## DECISION DELEGATED TO HEAD OF PLANNING

**Application No:** H08-0852-25      **Applicant:** Mrs K M Baxter  
**Proposal:** Demolition of Existing Barns & Erection of 2 Dwellings  
**Location:** Belnie House Farm Buildings Belnie Lane Gosberton  
**Terminal Date:** 6th November 2025

**SITE PLAN PROPOSED & LOCATION PLAN
(DWG 4301-24 09)**

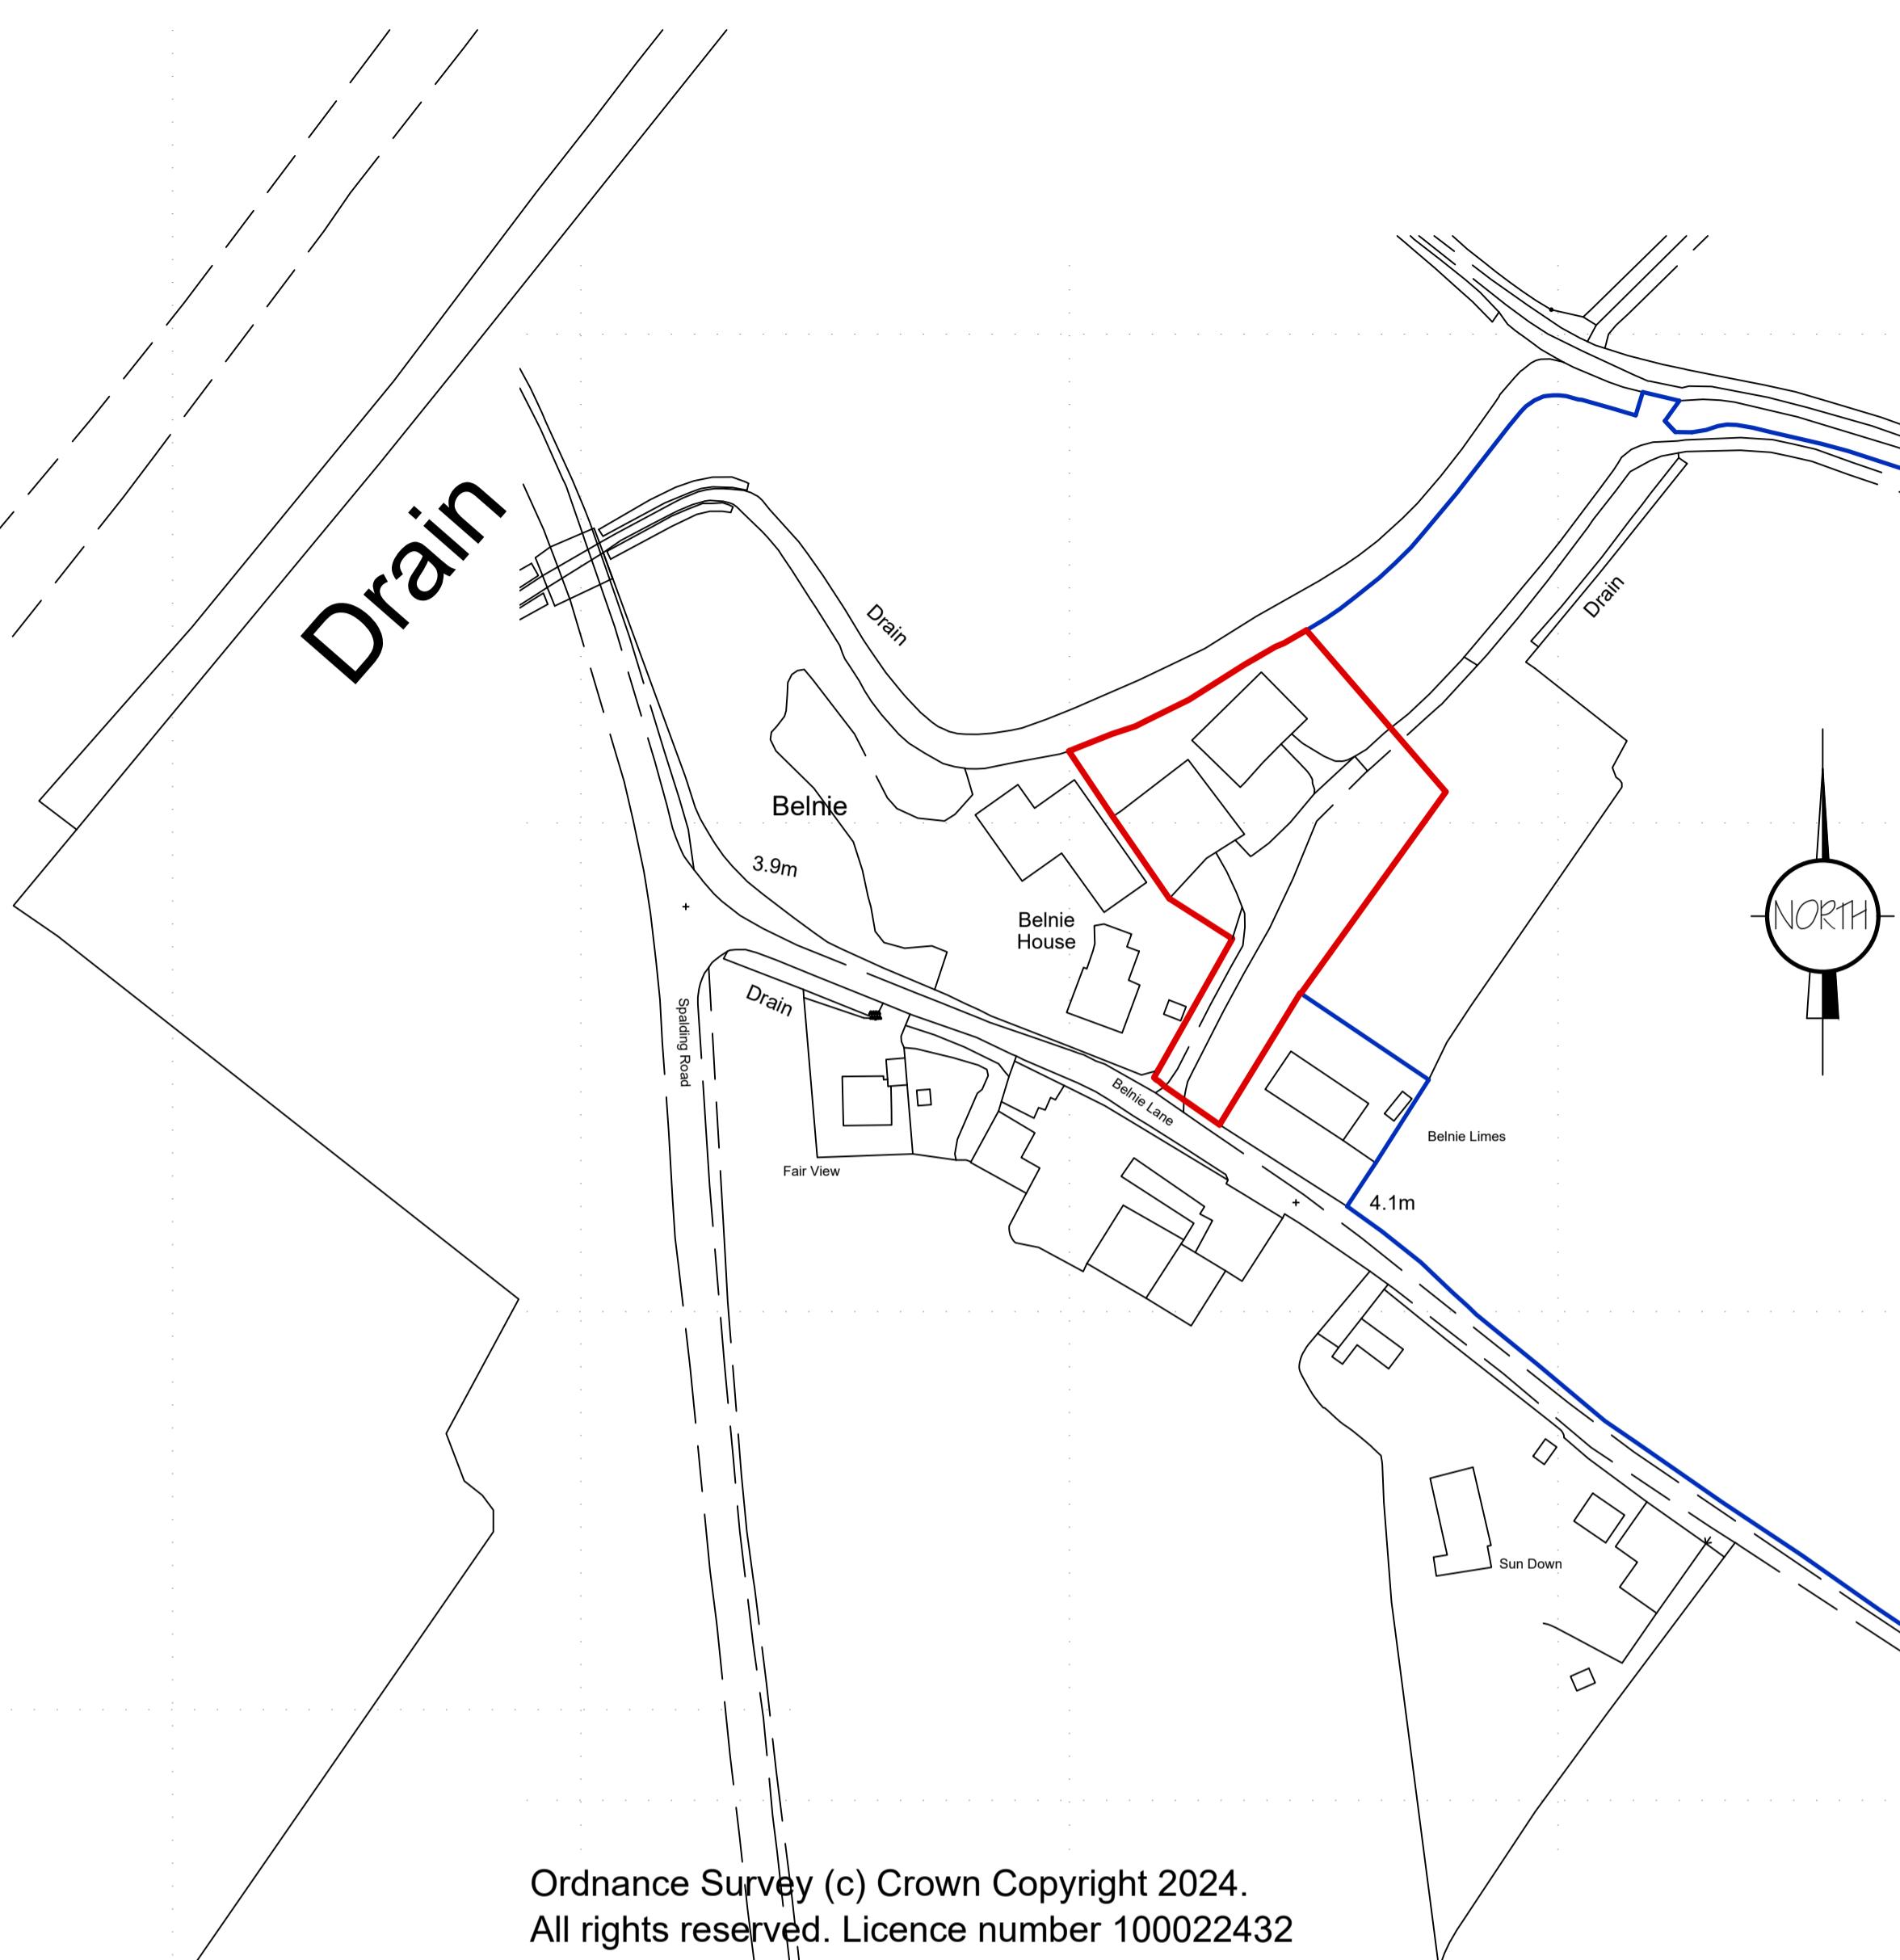
Lincolnshire County Council - Highways and SUDS: Parking spaces and turning need to be detailed on the site plan

Lincolnshire County Council's (LCC) highways team have requested that the parking spaces and turning area within the site are detailed on the site plan. The team have not objected to the proposed access or queried the visibility splays for the site access junction. It is noted that the highways team did not raise any objections in terms of highway safety for the previous prior approval applications within the site. It is considered that there is sufficient room for parking and turning within the site for at least 3 parking spaces for both dwellings. Therefore, the proposal would be acceptable in terms of highway safety, in accordance with Policies 2, 3 and 36 of the Local Plan, and Section 9 of the NPPF.
